Preferred Project Report Construction of a Mixed Use Retail / Residential Building

Frasers Broadway
Block 2

Submitted to
Department of Planning
On Behalf of Frasers Broadway Pty Ltd

February 2010 ■ 09112

PLAN OF PROPOSED SUBDIVISION OF LOT 3 IN
FRASERS BROADWAY SUPERLOT SUBDIVISION

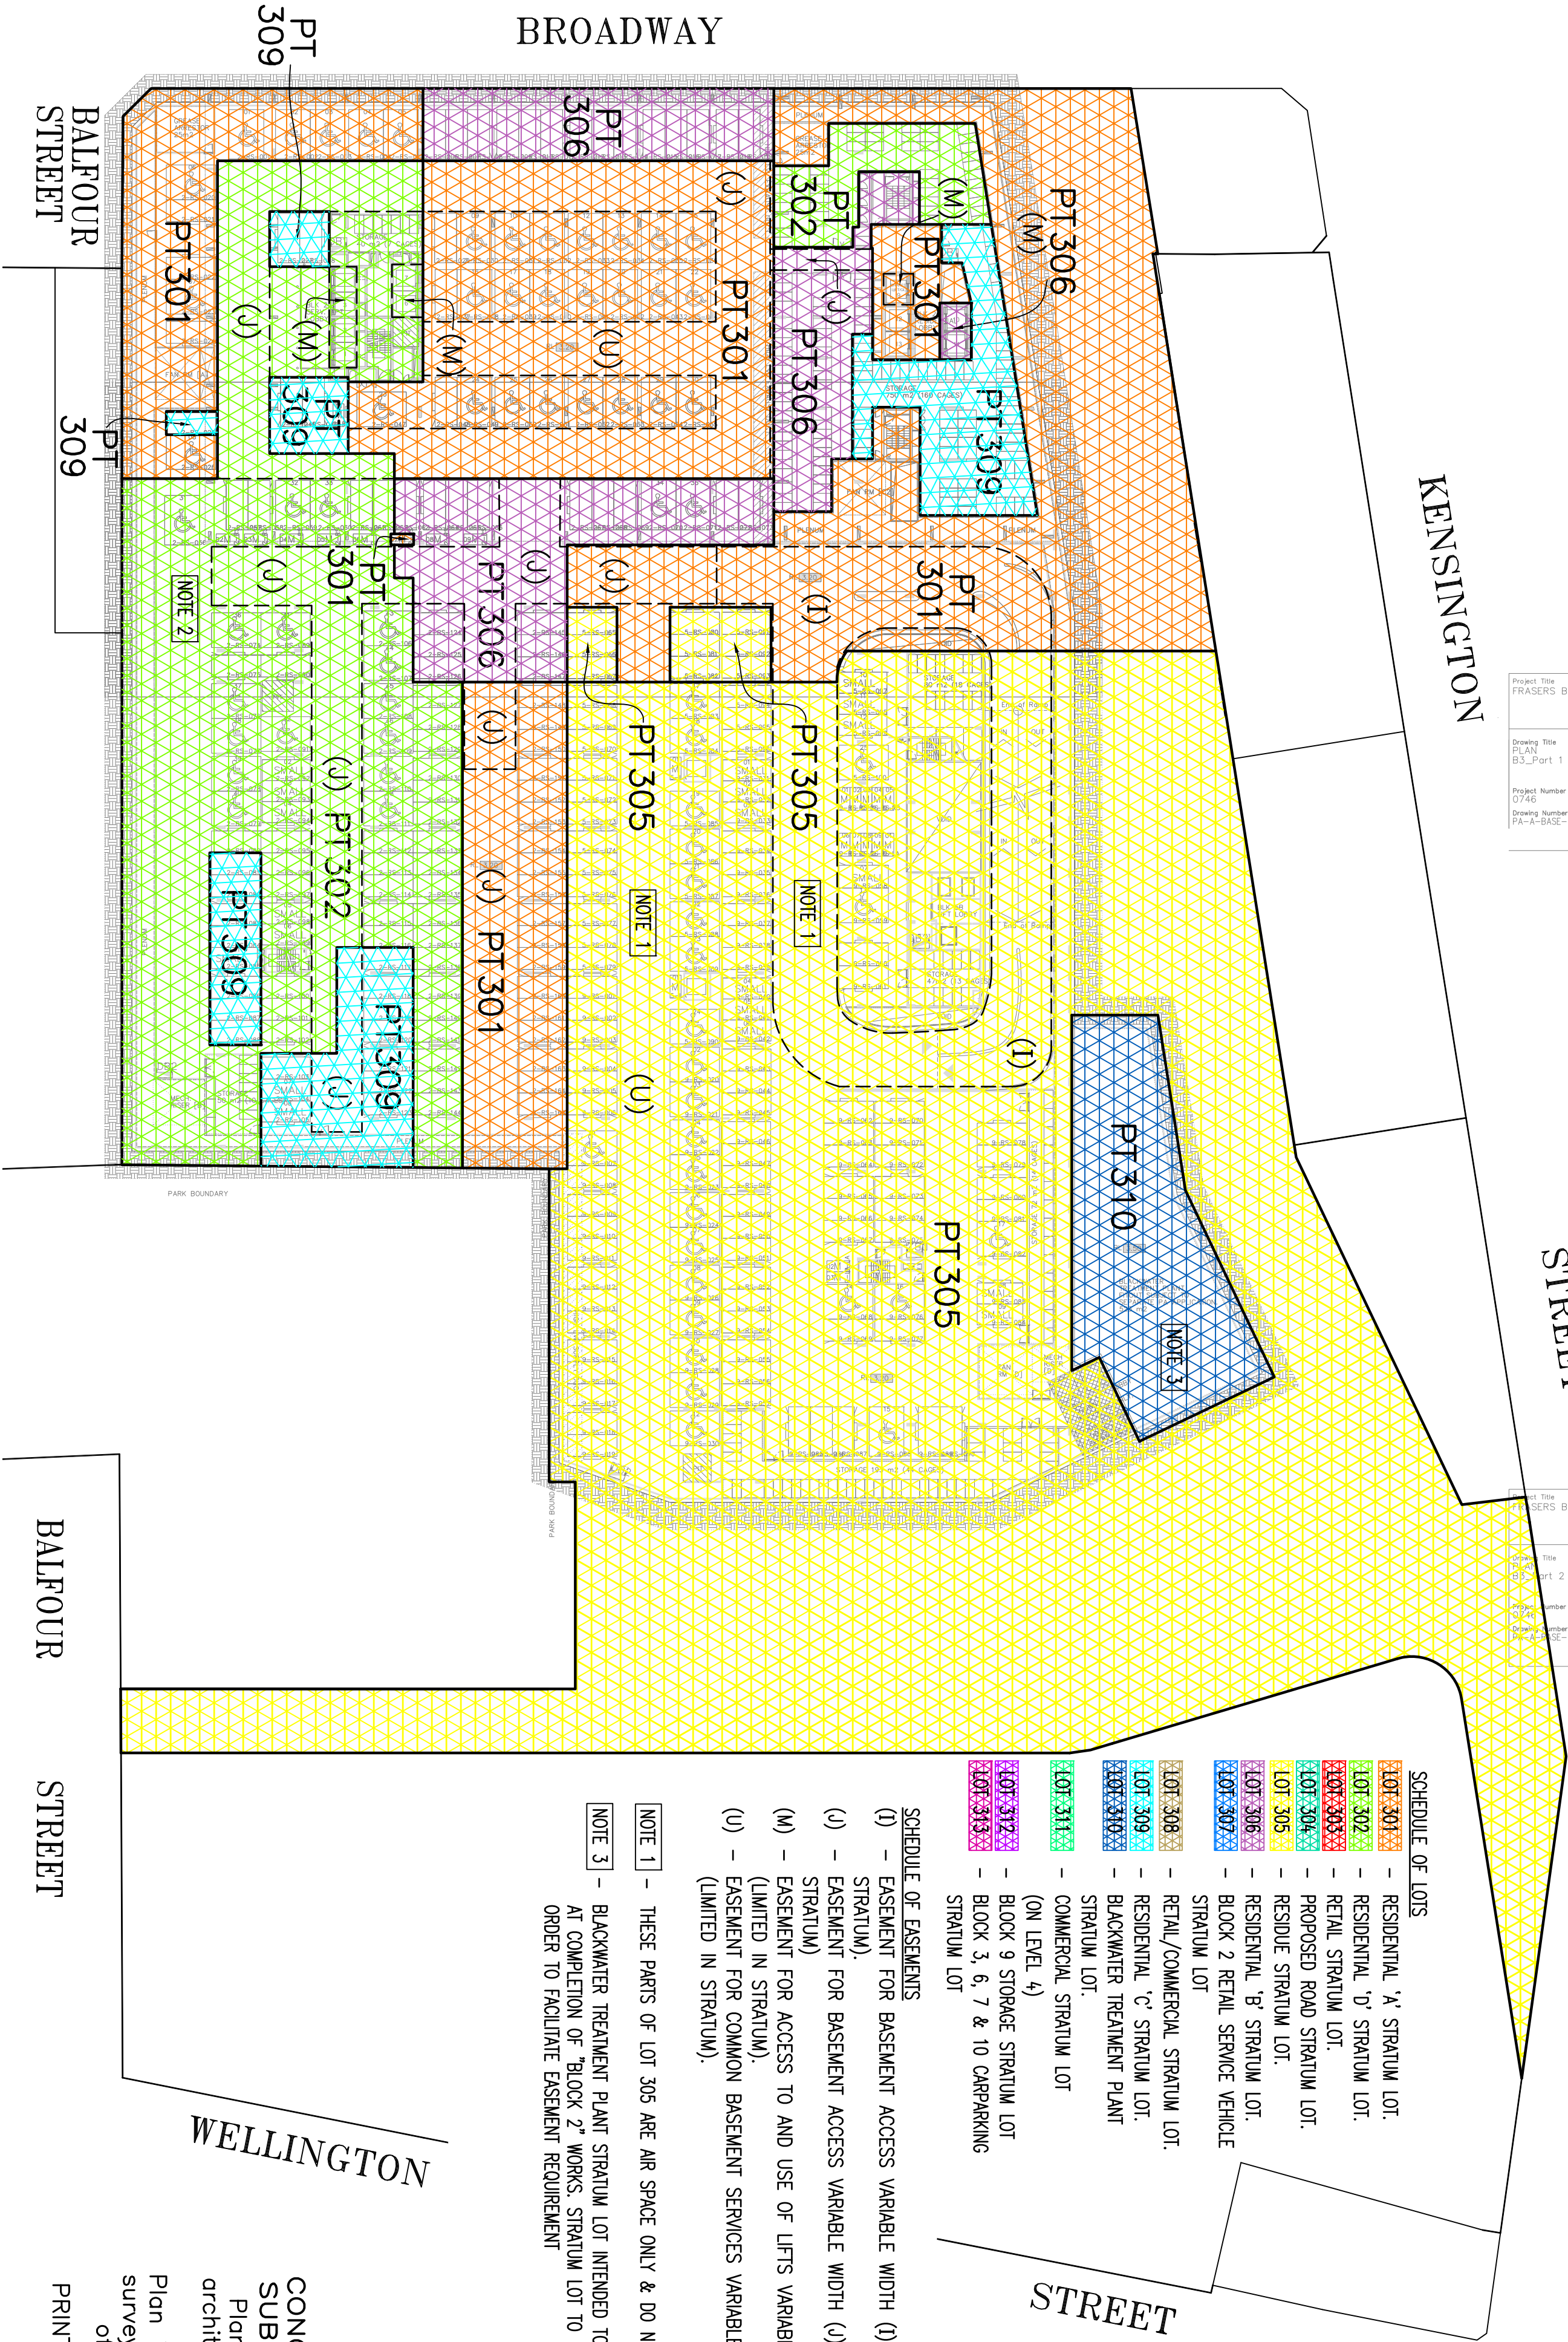
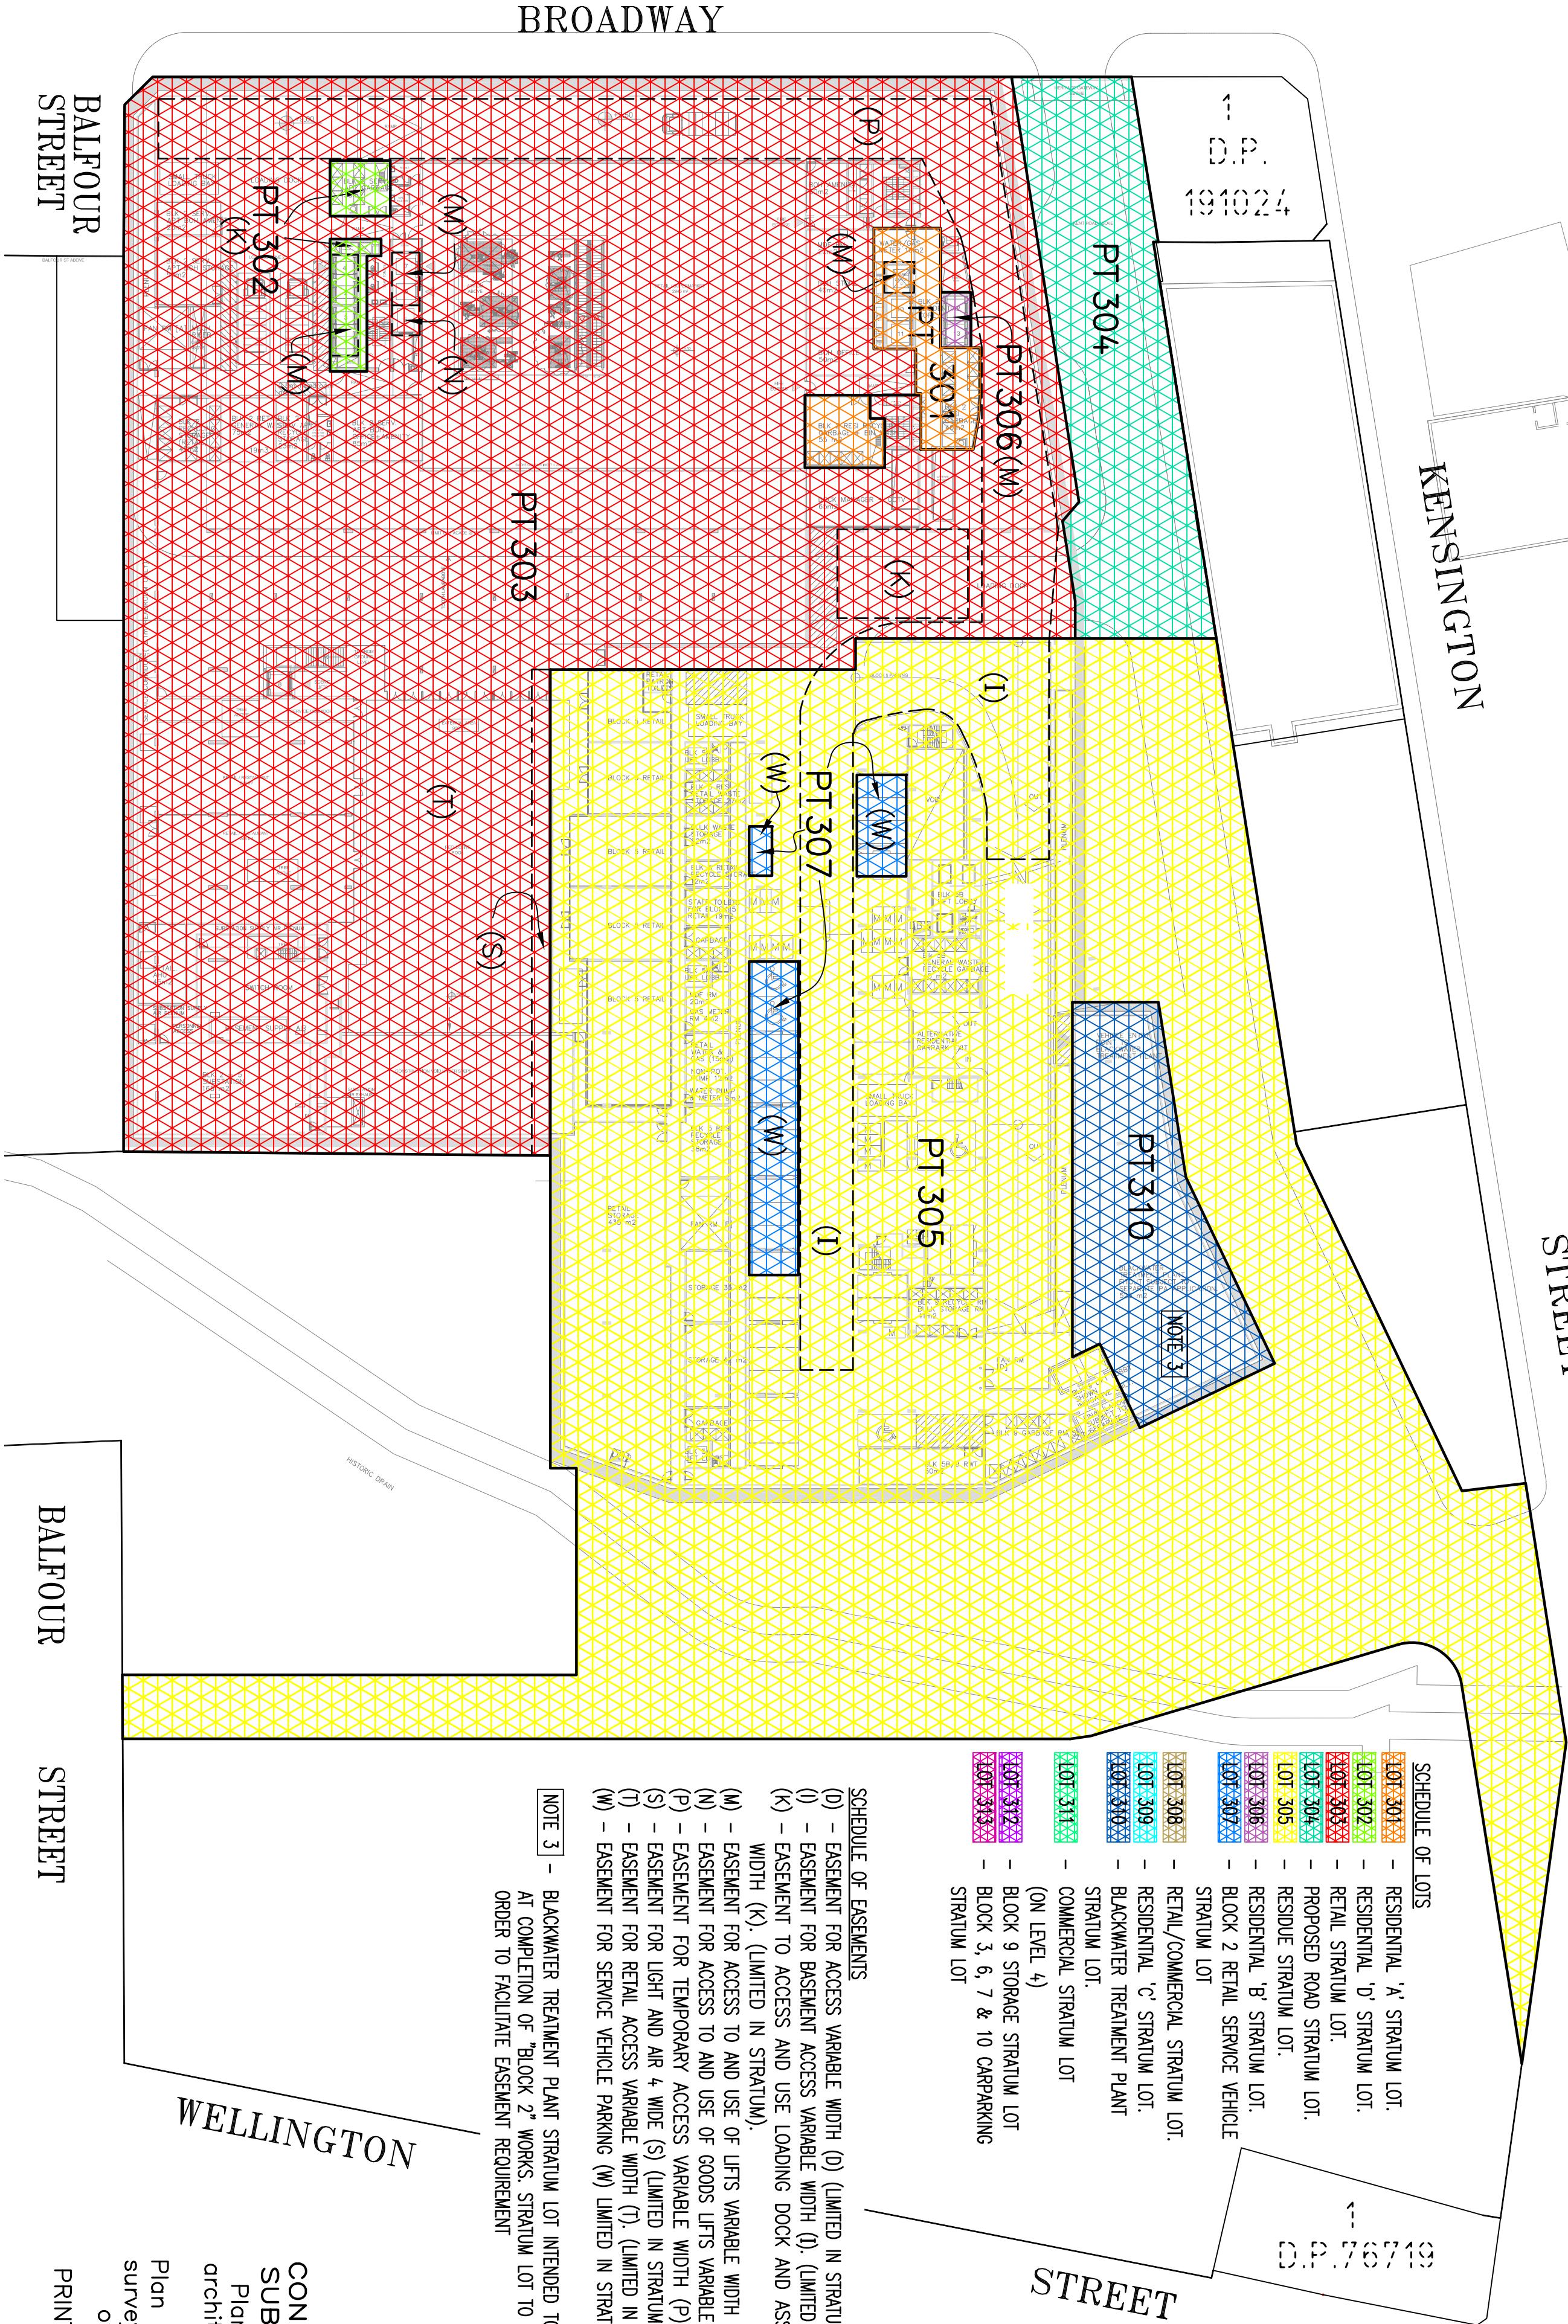
“Further additional details are to be provided in relation to the proposed stratum subdivision, including the ownership of the allotments within the subdivision and a detailed explanation of items contained within each allotment.”

“As the stratum subdivision relates to additional floor levels not provided within the EA, relevant plans are to be submitted for assessment to confirm that the proposed allotments have been correctly identified.”

“An additional set of plans is to be provided in colour and overlaid with the revised stratum subdivision plans taking into consideration details submitted for the basement project application.”

Revised Stratum Subdivision Plans, prepared by Denny Linker Pty Ltd are provided at **Appendix H** as requested.

The information on ownership is as follows:
